City of Albuquerque Stormwater Construction Site Inspection Report

ESC File No.	C18E088	Project Name:	The Peaks by Markana Ph I		
NPDES Id. No.	NMR1003VA & NMR1003VB	Location:	6700 Modesto Avenue NE		
12/4/2023	Owner	Contractor			
Operator	KLK 9, LLC.	Kasam Construction			
Contact name & title	Faizel Kassam	Stephen Pendergraft			
e-mail	fkassam@legacy-hospitality.com	Spendergraft@Legacydm.net			
Contact Phone #	505-489-4474	720-7188			
COA Inspector	Doug Hughes	Start/End Time:	11Am		
Construction Phase:	Interior finish - 80% paved - 0% occupied				
Type of Inspection:	Regular	Storm Event	Past Storm Event >0.25"	311/Complaint	Follow Up
Weather at time of inspection?		Cloudy	Temperature:	~	45
Estimated date of last storm 0.25" or greater		11/19/2023			
Item Number	Deficiency/ Corrective Action				
1	none				
2					
3					
2.1	Discharge off site? (Y/N)	No			
4	Self Inspection Reports	ok	Latest report Date:	11/27/2023

NAME: N:\Projects\03711 legacy\modesto3.dwg\Sheets\C-101 OVERALL GRADING PLAN.dwg PLOT DATE: Feb 04, 2022 1:13pm

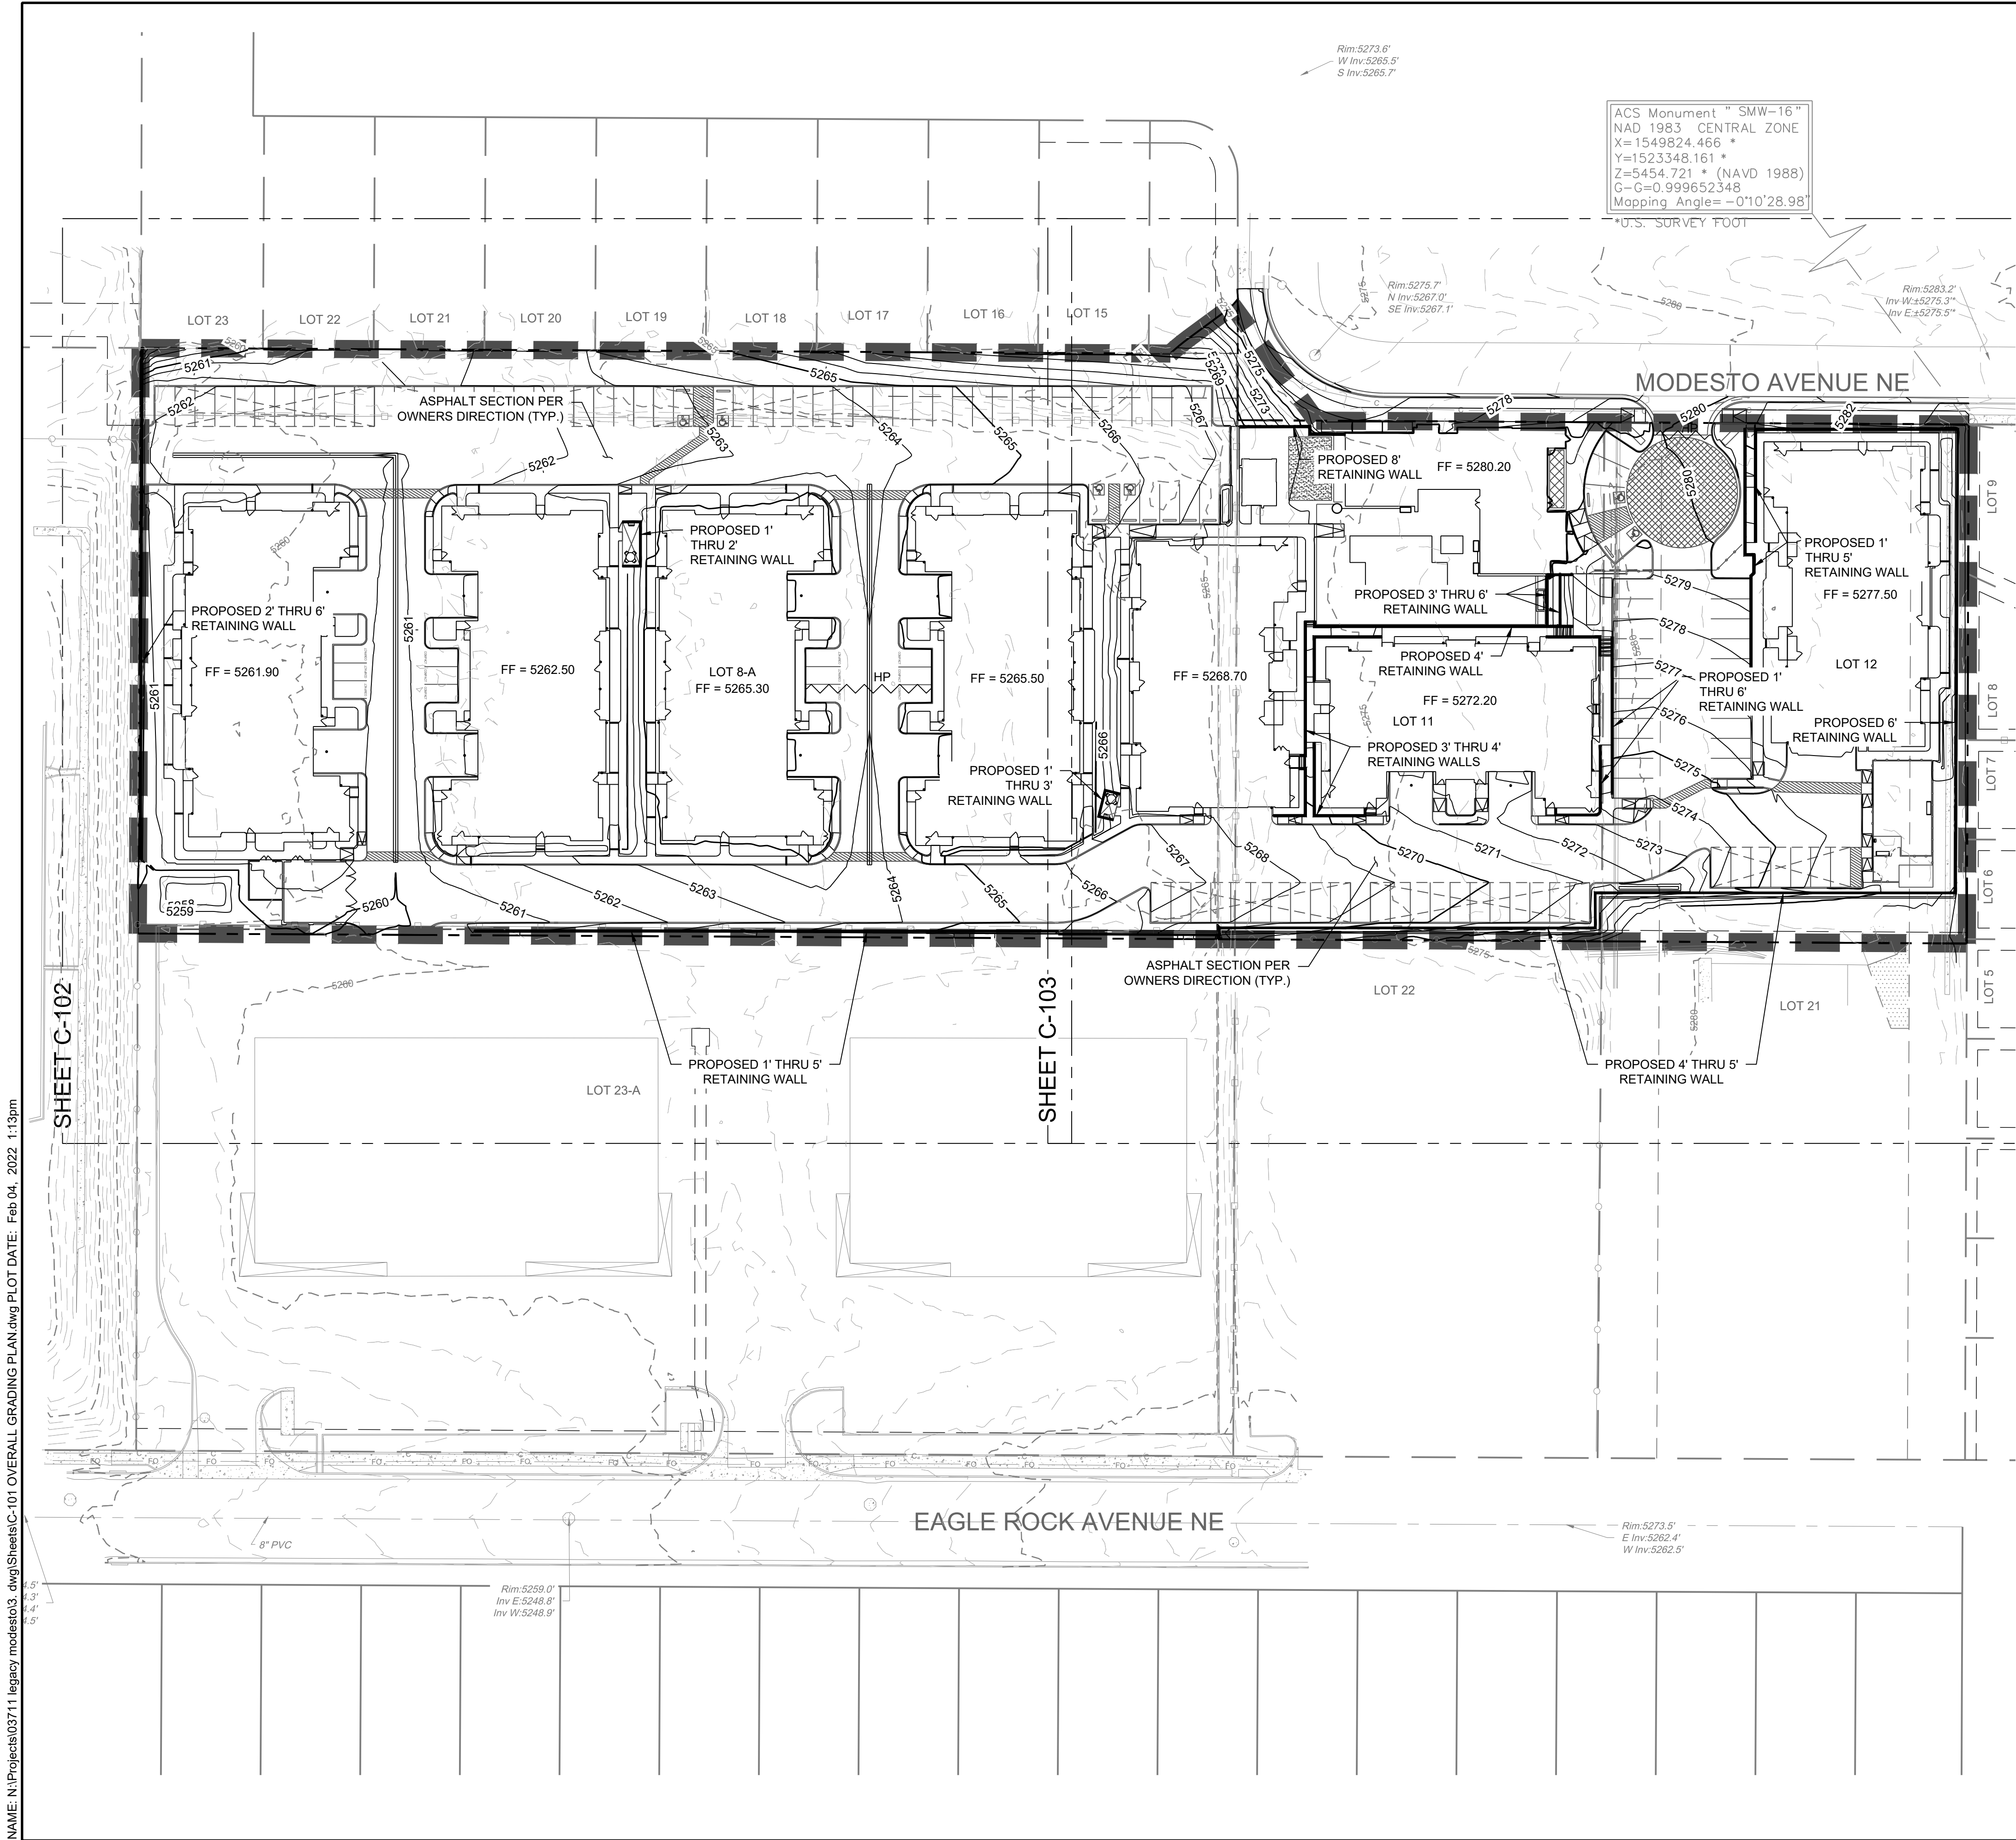
All previous violations have been mitigated. The SWPPP is in the construction office in the middle south apartment. The sediment basin appears to be sized for the 2-yr storm, but the overflow isn't defined and may cause damage to neighboring property to the west. The west wall has many drain holes, but the G&D plan shows that the entire site is supposed to drain into the property to the south. The drain holes in the west wall are at the same elevation as the south driveway. Stephen Pendergraft added the pond to the SWPPP map, but his professional consultants should check the pond's design and safety.
